KITTITAS COUNTY COMMUNITY DEVELOPMENT SERVICES

Kittitas County Community Development Services has determined that the Reecer Creek Short Plat (SP-07-143) is a complete application and hereby grants **conditional preliminary approval** subject to the following conditions:

**REECER CREEK SHORT PLAT
 PART OF SECTION 28, T. 19 N., R. 18 E., W.M.
 KITTITAS COUNTY, WASHINGTON**

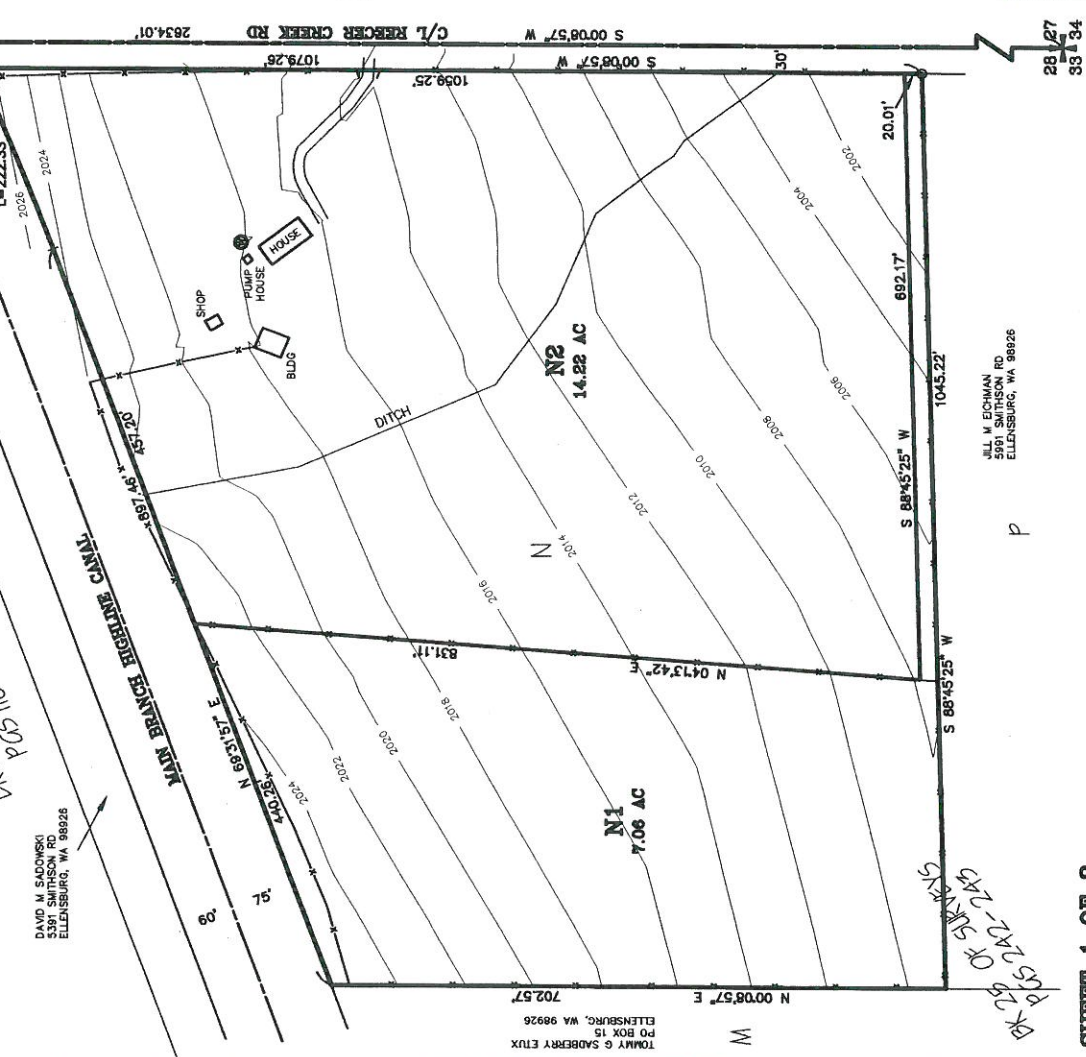
1. Both sheets of the final mylars shall reflect short plat number SP-07-143 and an accurate legal description shall be shown on the face of the final plat.

4. Per Kittitas County Environmental Health, proof of water availability is required and soil logs need to be done.
5. This property is in within the boundaries of the Kittitas Reclamation District (KRD) and both parcels contain irrigable ground. Proof that all KRD General Guidelines have been met is required prior to final approval.
